From: Peter Cleveland
Sent: 03 April 2014 11:20
To: 'James Neave'
Cc: Nat Slade
Subject: RE: WSCC/096/13/F - Ford Waste Treatment Facility - Further Information

Your Ref: WSCC/096/13/F.

Our Ref: F/19/13

Proposed development and operation of a waste treatment facility. This is a County Matter and will be determined by West Sussex County Council.
New Circular Technology Park, Former Ford Blockworks, Ford Airfield Industrial Estate, Ford

REVISION			
PROJECT		Proposed conversion of Grain store building, Ford Airfield	
SUBJECT		Block Plan and Location Plan	
SCALE	DATE	DRAWING No.	
1:1250 & 1:500	Feb 2011		
DRAWN	CHECKED	11 / 09 / 03

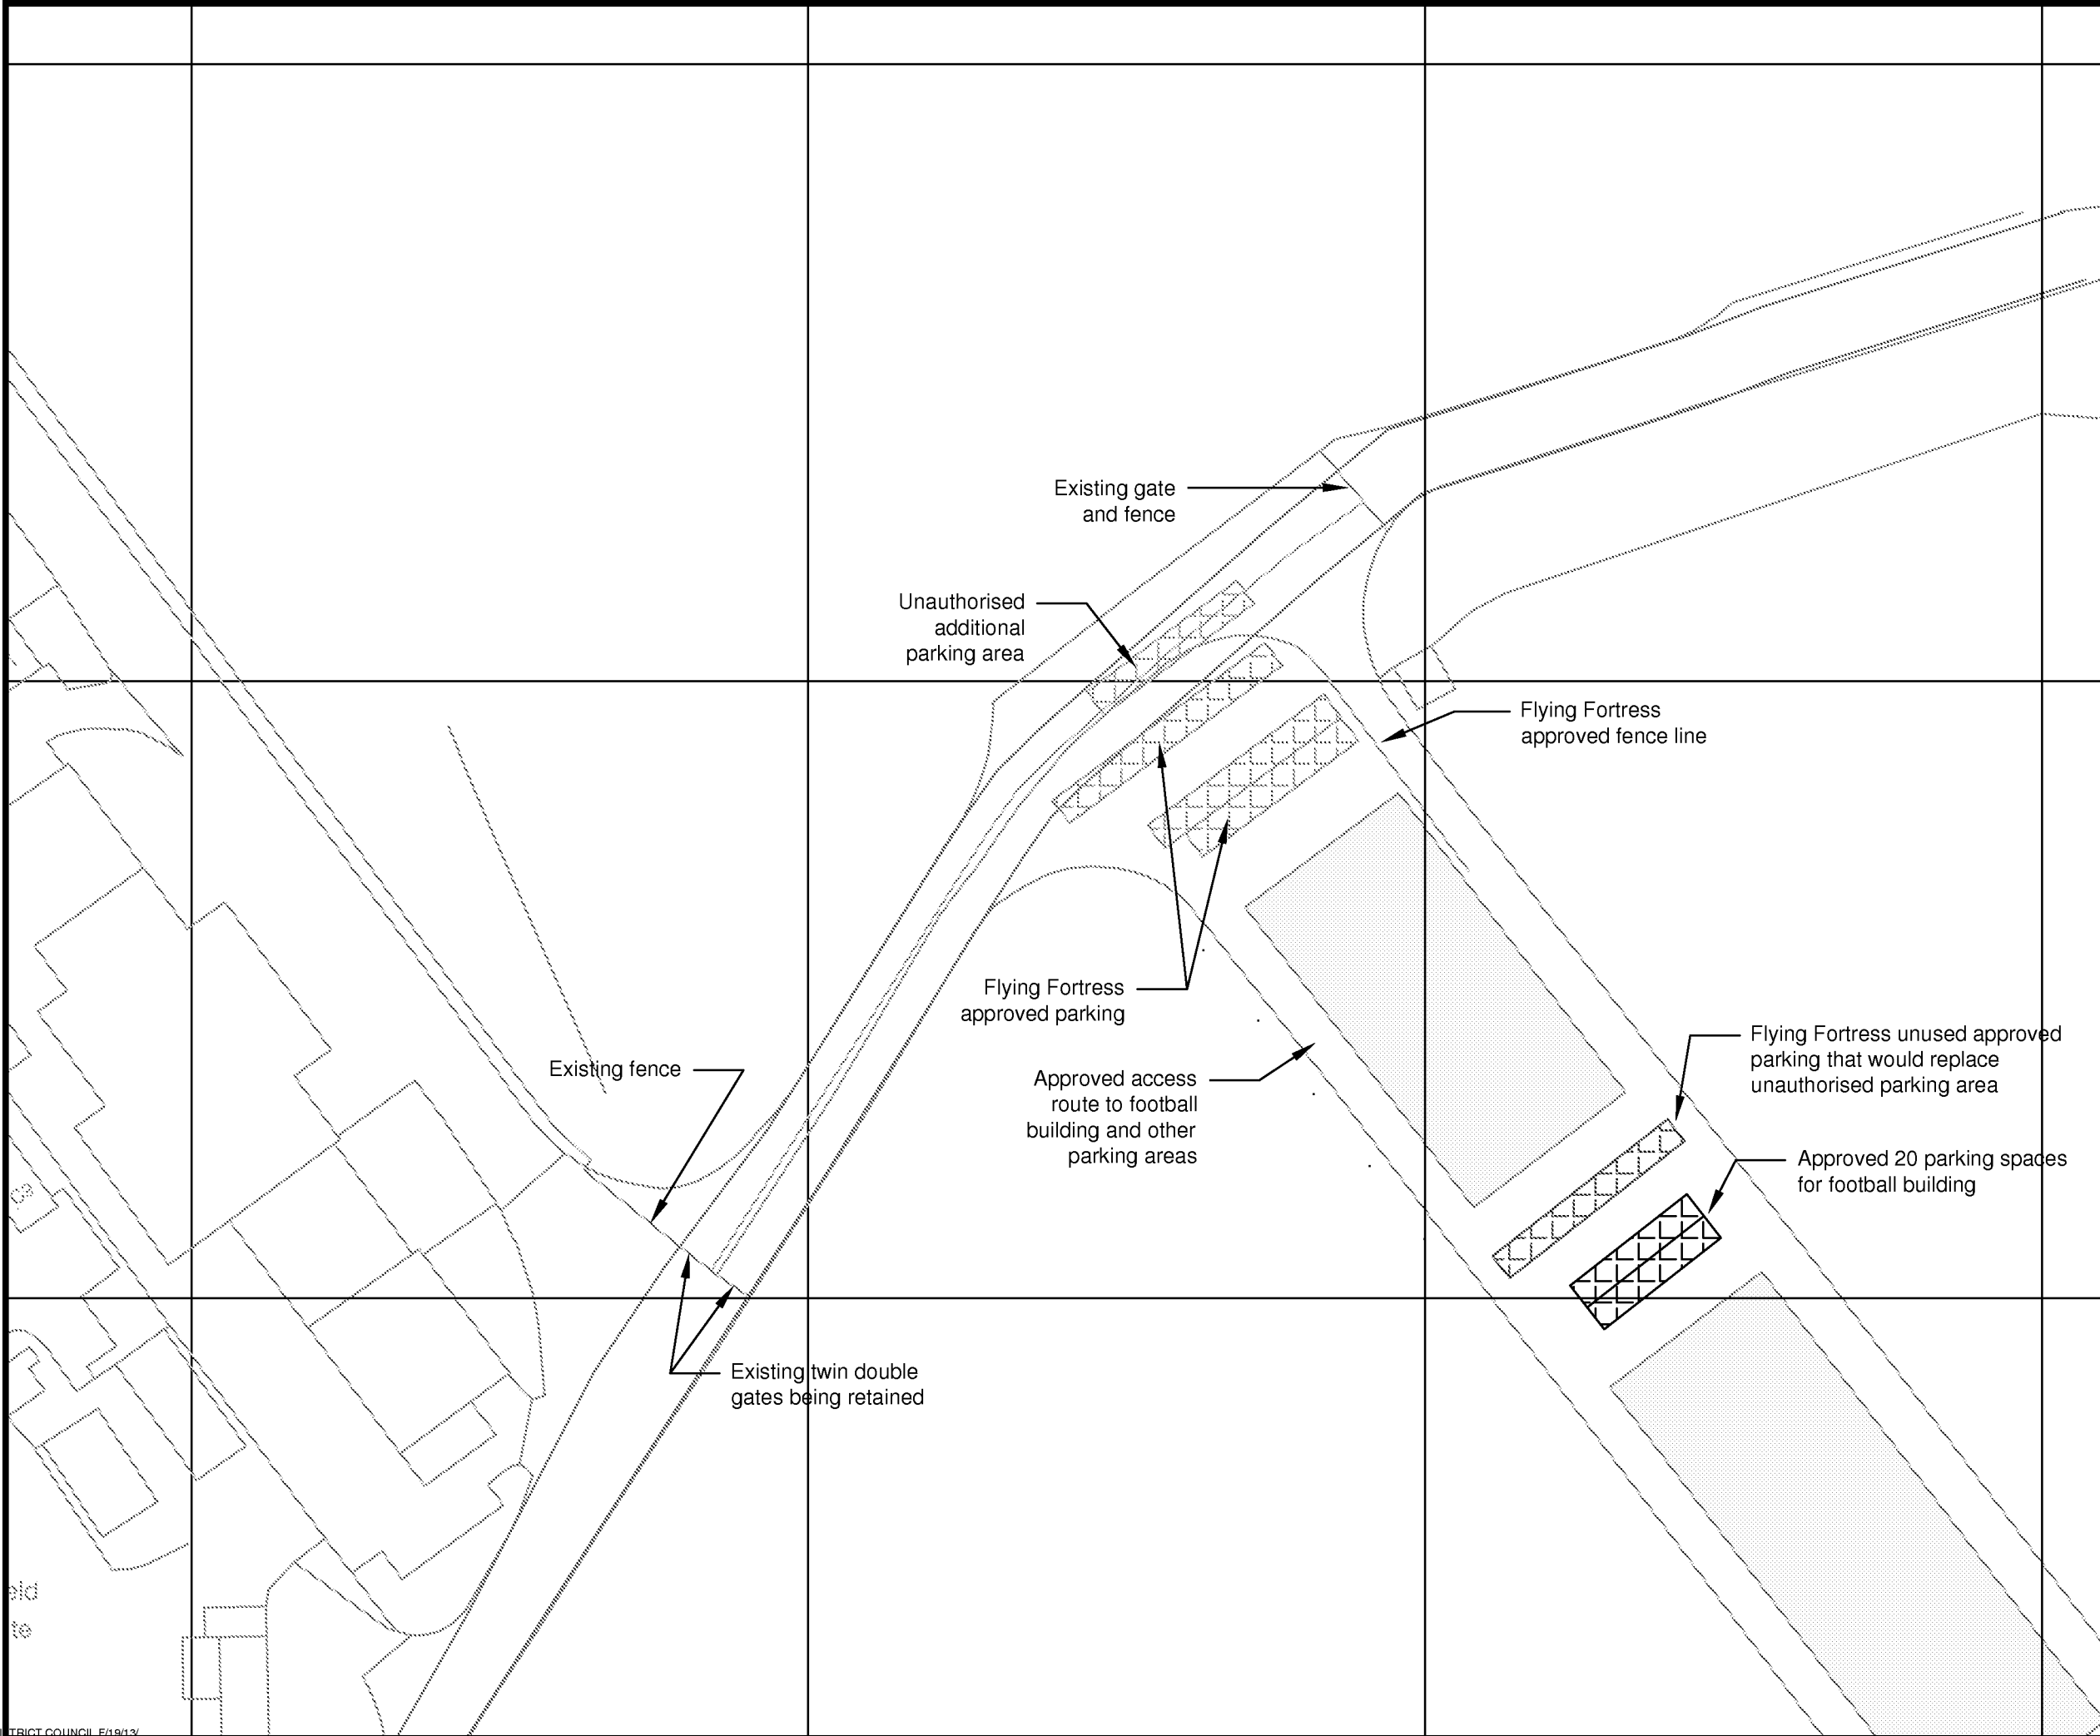
I can confirm that drawing No. 10353/021 approved under F/1/04 identifies the approved parking layout for the Flying Fortress, and drawing number 11/09/03 approved under F/5/11 is the approved parking layout for the indoor football facility.

I have discussed the issue of parking provision and the restriction it imposes upon the access into the waste facility site with colleagues within our enforcement team. Given that the existing parking arrangement for the flying fortress has been in place since the use commenced (March 2005) the Council would not seek to regularise this position. It is my colleague's view that the approval of the indoor football use did not affect the existing parking arrangements for the Flying Fortress which was already established at the front and side of the site. I have also noted the comments in the letter from Flying Fortress stating that parking is lost to the side of the building to allow service/delivery vehicles to the rear, this needs to be addressed by the operator/owner of the site to ensure they can provide the appropriate level of parking and access for the existing use.

It is our view that the parking issues should be addressed by the land owner to ensure that suitable access and parking can be accommodated for both of the sites. I would therefore confirm our position that we would not be taking enforcement action against the existing parking layout.

South Elevation

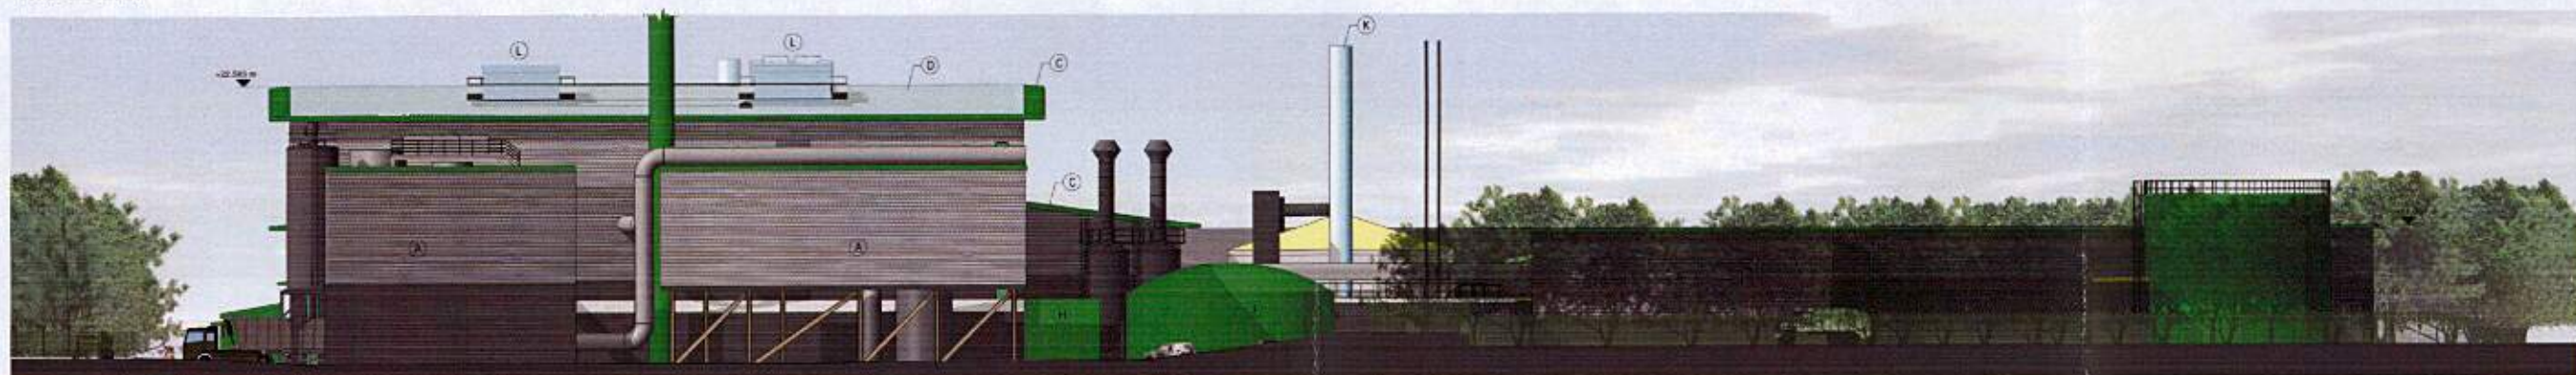
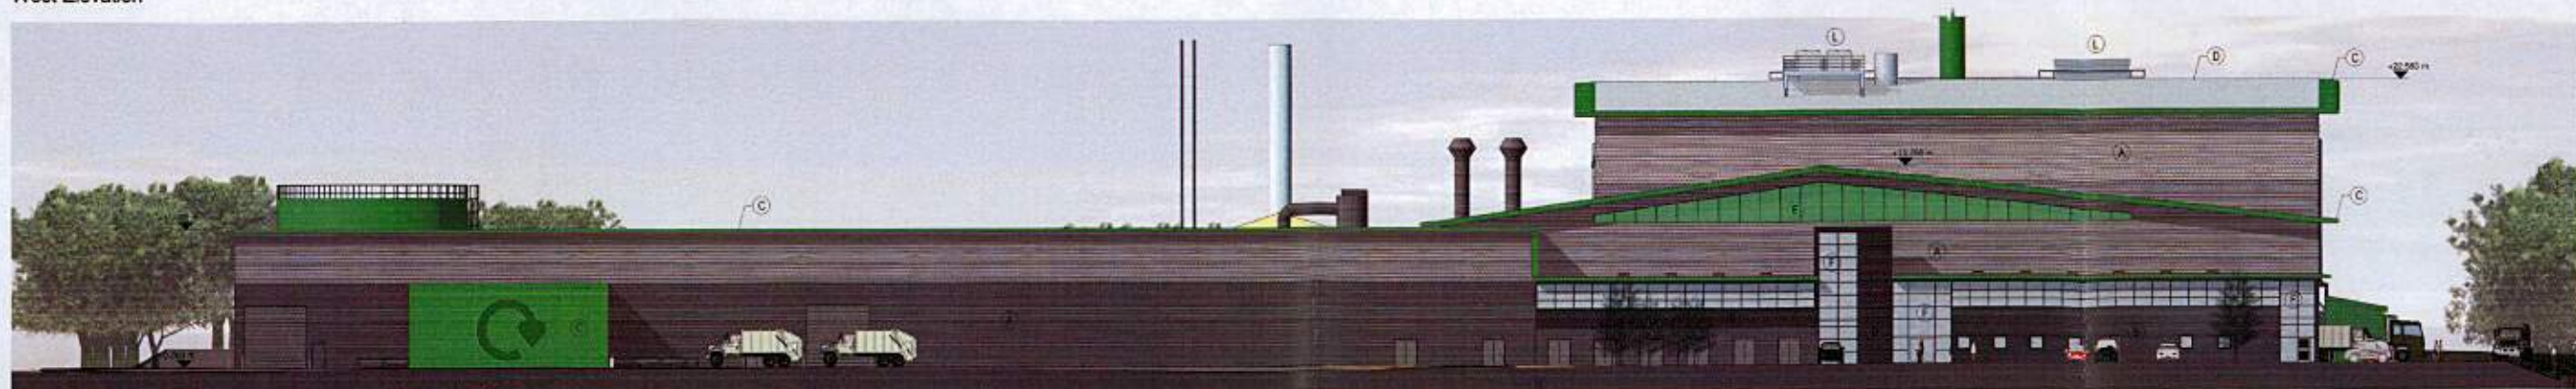
Thank you for highlighting the further information regarding the stack height, I note the comments made from paragraph 5.3 which satisfactorily addresses the district concerns over the justification of its height. There is still concern that there is a visual impact as a result of 50m high stacks, however with the justification given to ensure that air quality impacts are significant reduced by choosing the stack height of 50m rather than 45m the District would accept the visual impact.
